HyNet Pipeline Development Consent Order

Our ref 41915/03/JG/MKR
Date 4 July 2023
From Encirc

Subject Encirc Deadline 5 Representation

EN070007-D.2.2-LP-Sheet 1

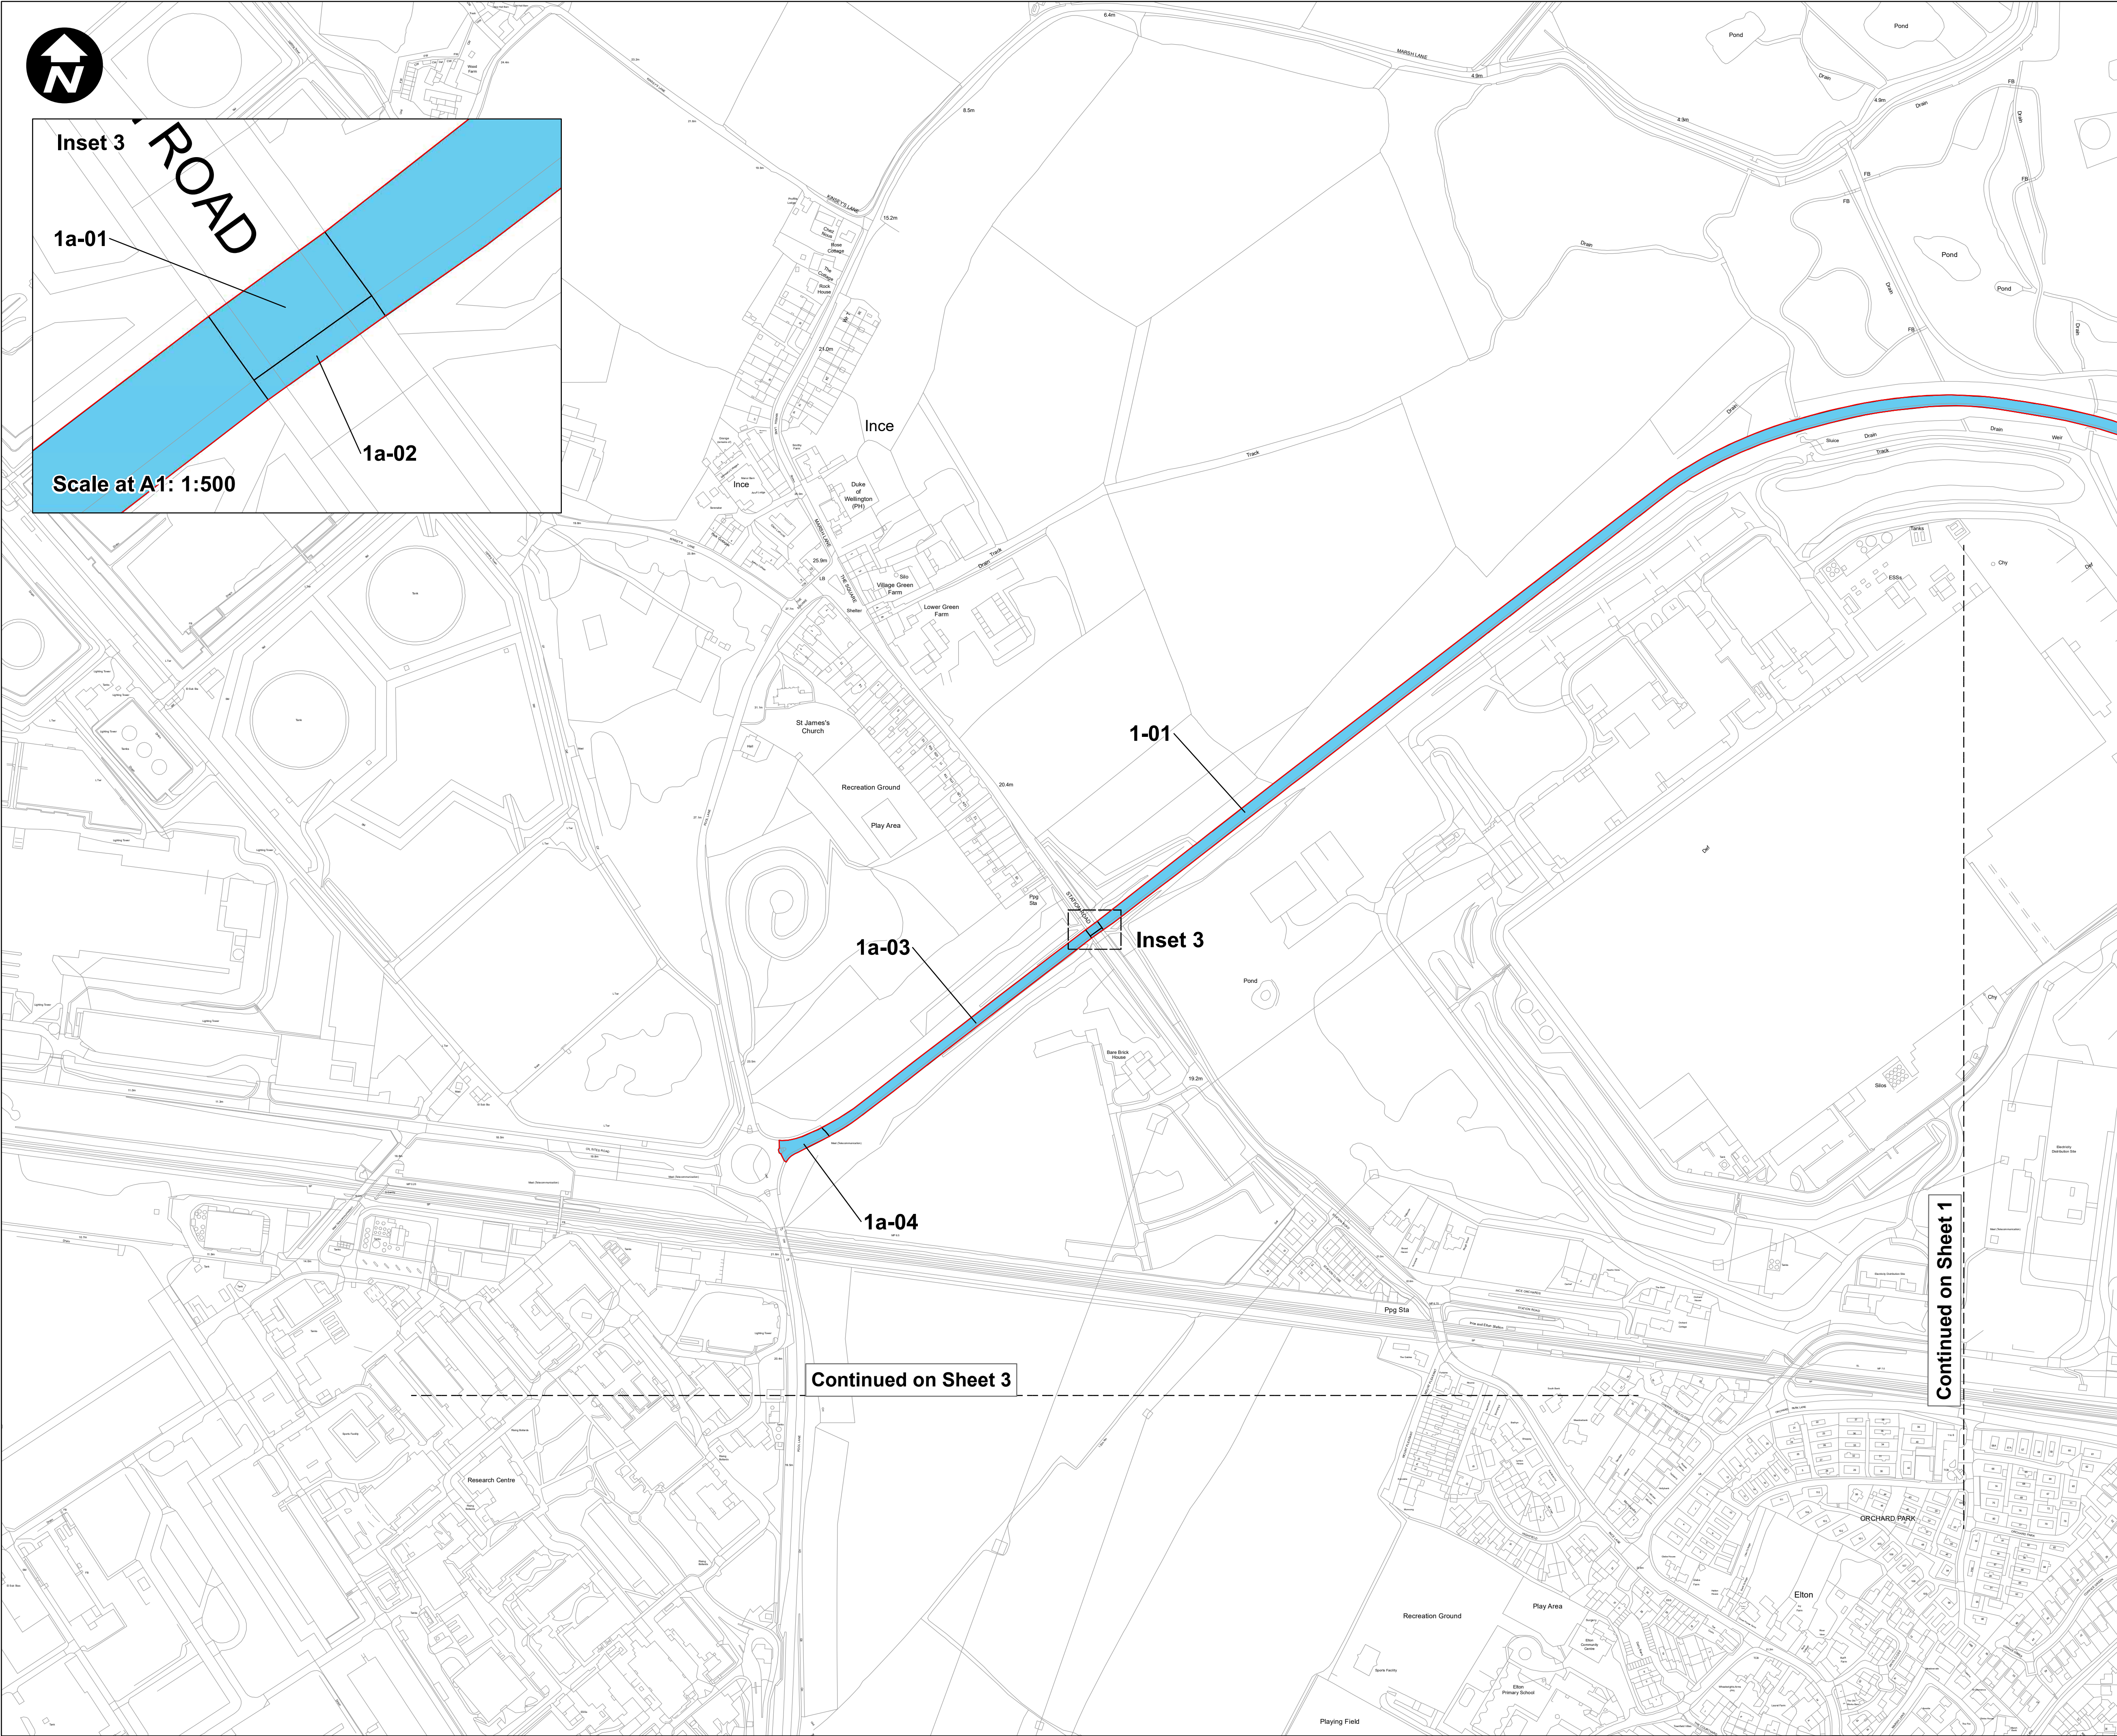
- 2.4 Encirc has requested that rights of access over plot 1-21 are downgraded to temporary in order to safeguard the future development of an enhanced rail facility, which will be located approximately 300m along the existing rail lines. This new facility will include new rail sidings and an intermodal area. It is important that the applicant confirms that their land interest/temporary access right will not prejudice the implementation of this rail enhancement scheme. Following the meeting between Encirc and the Applicant on 23 June 2023, the rights of access over 1-21 remains subject to further discussion between the parties. Until a solution is agreed, whether it be through Protective Provisions or by downgrading 1-21 to temporary rights of access, Encirc’s objection still stands.
